Your Ref: **32111000**
Our Ref: **G pre00220/2019**
(Please quote in all related correspondence)

06 July 2020

Re: Scoping Document for proposed replacement of 7 manned level crossings between Limerick Junction and Cork City on the Dublin-Cork Railway line.

Title: Interpretative Plan of geophysical survey results, Imphrick

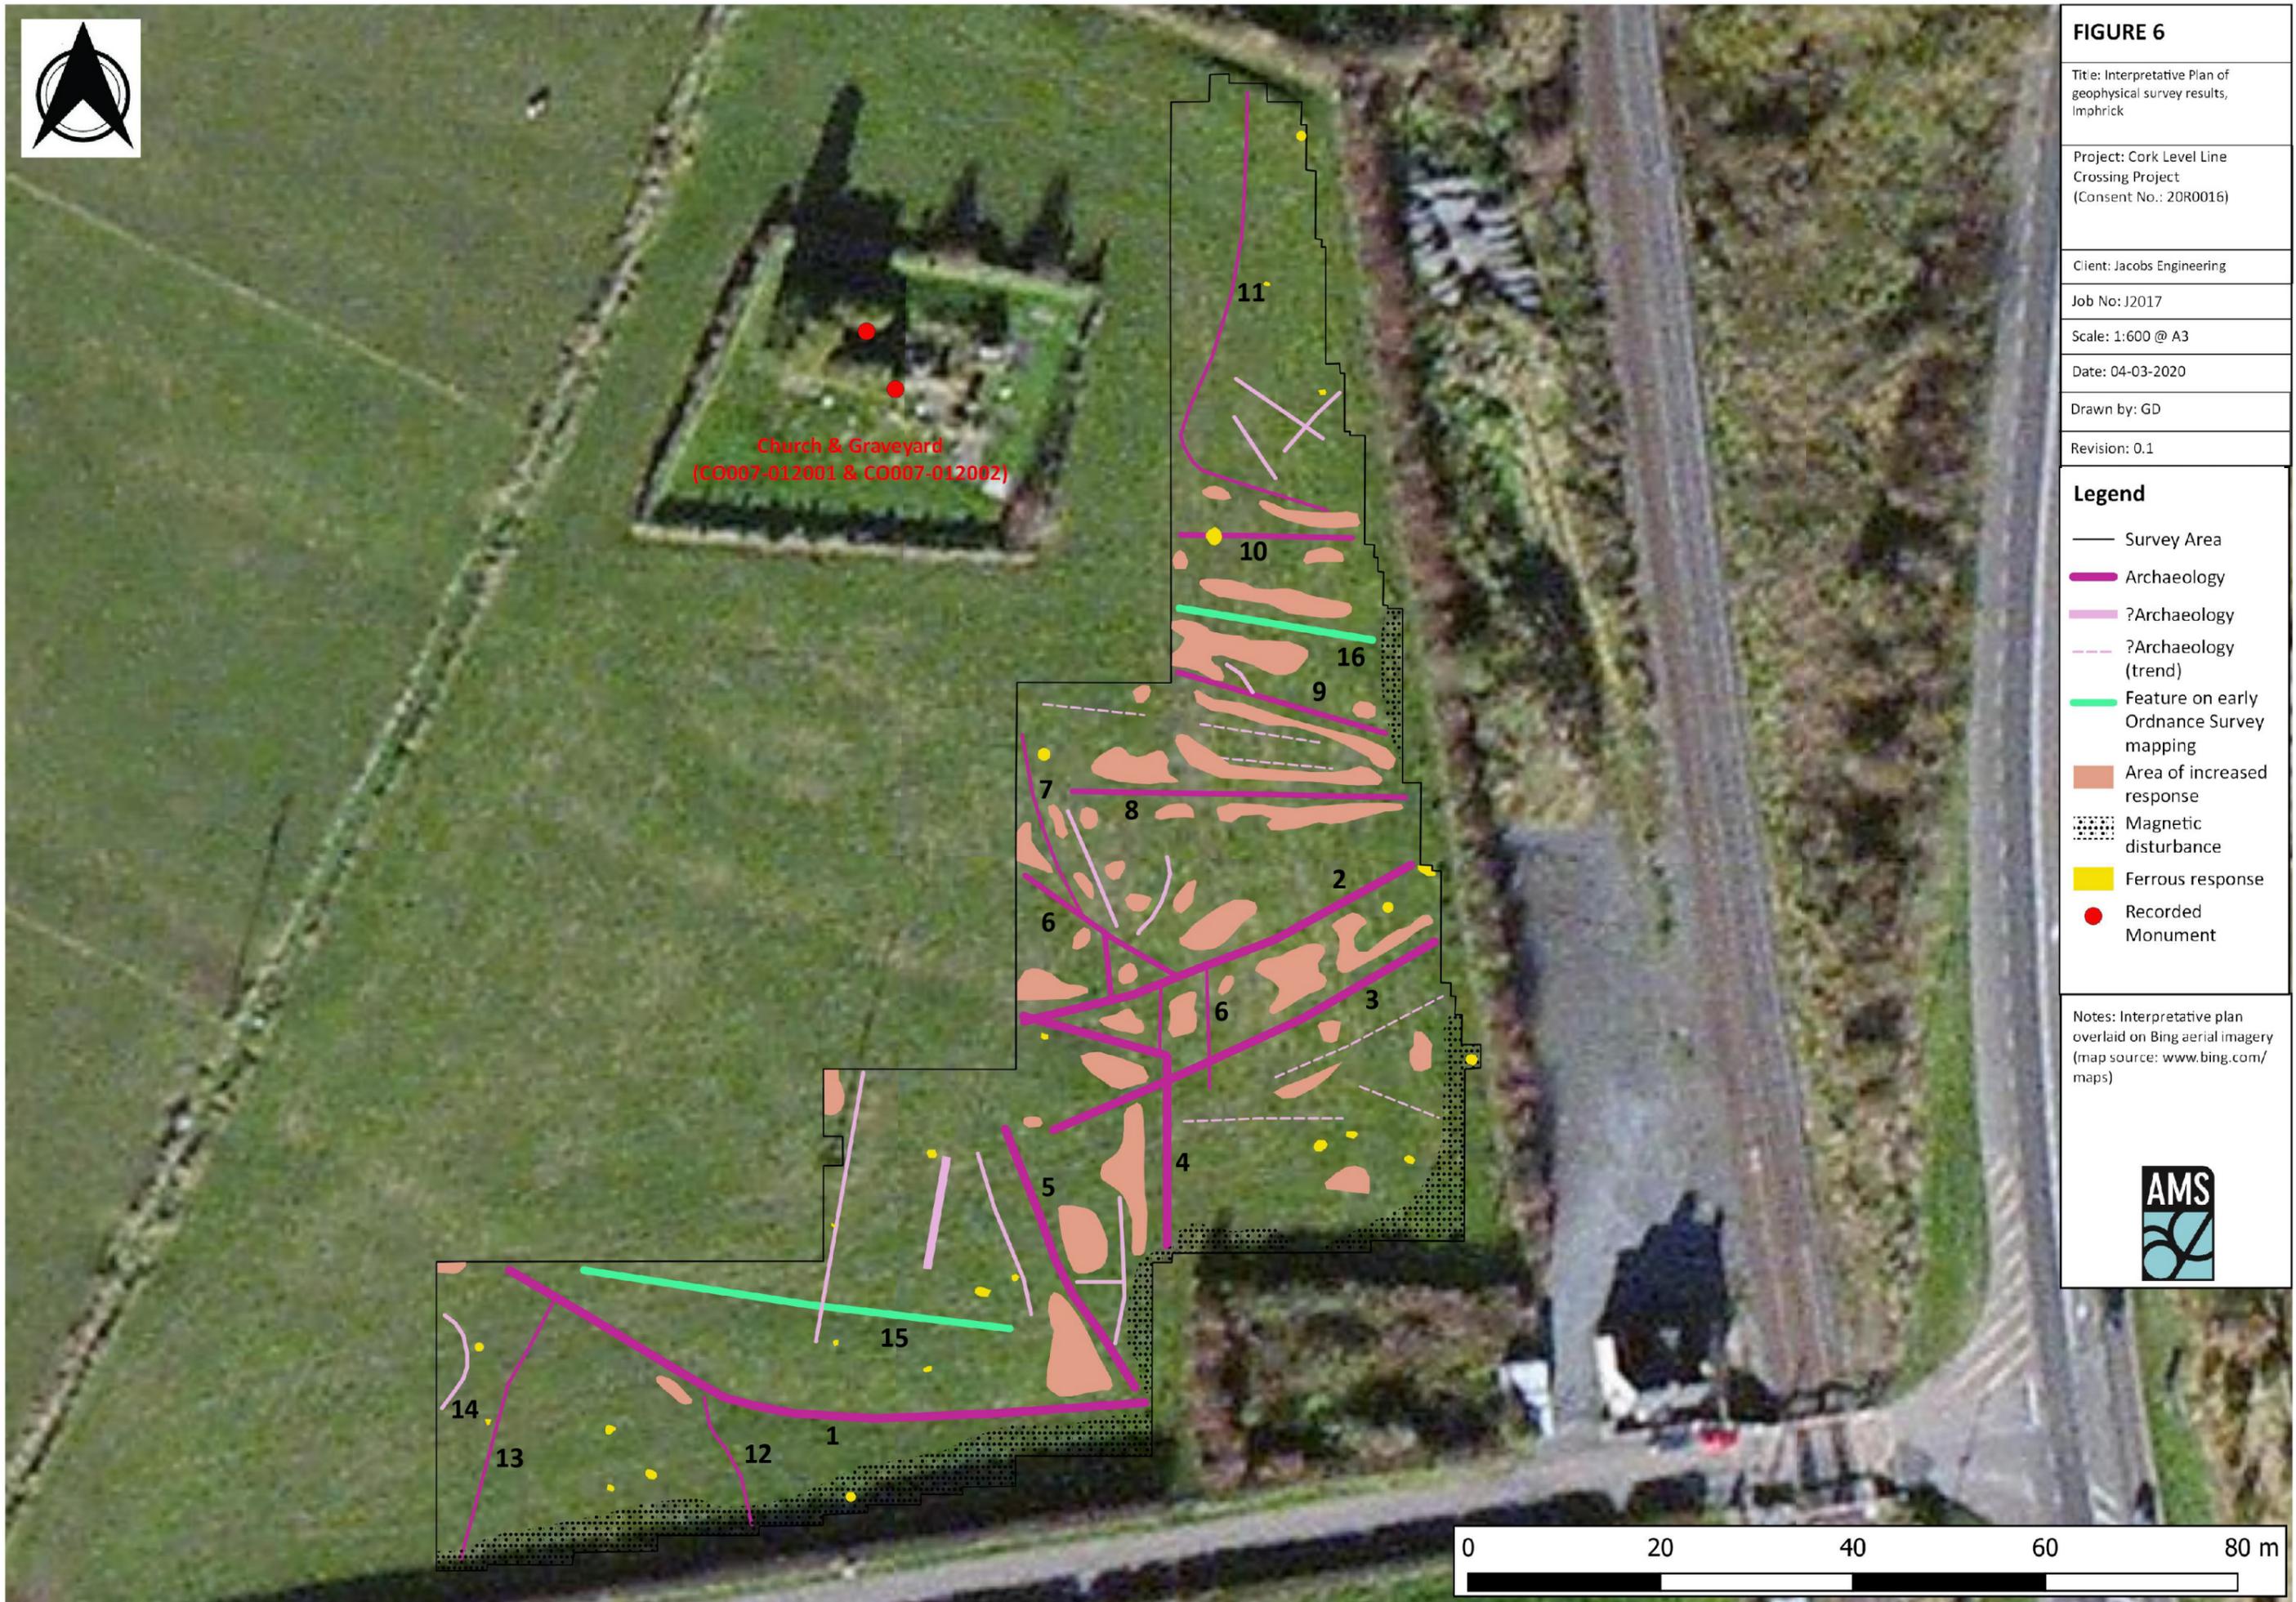
Report 20R0016 Shinanagh/Imphrick has recorded extensive and possibly archaeologically significant anomalies to the E/SE/S of Recorded Monument CO007-120(001-/002) *Church and graveyard*. Geophysics to the north of this monument has recorded a circular enclosure with extensive and possibly significant features within it – possibly representing a hut-site/souterrain/area of burning. There are also a number of features/low earthworks surrounding the enclosure itself.

3. Given the extensive and possibly significant archaeological earthworks/features, including a newly recorded upstanding enclosure, at Shinanagh/Imprick, a programme of targeted archaeological test excavation is required. This will establish the location, nature and extent of archaeological features/deposits revealed during geophysical survey and field survey. In particular the nature of the earthworks to the E/SE/S of RMP CO007-120--- needs to be established in tandem with the newly recorded enclosure and its' associated features.
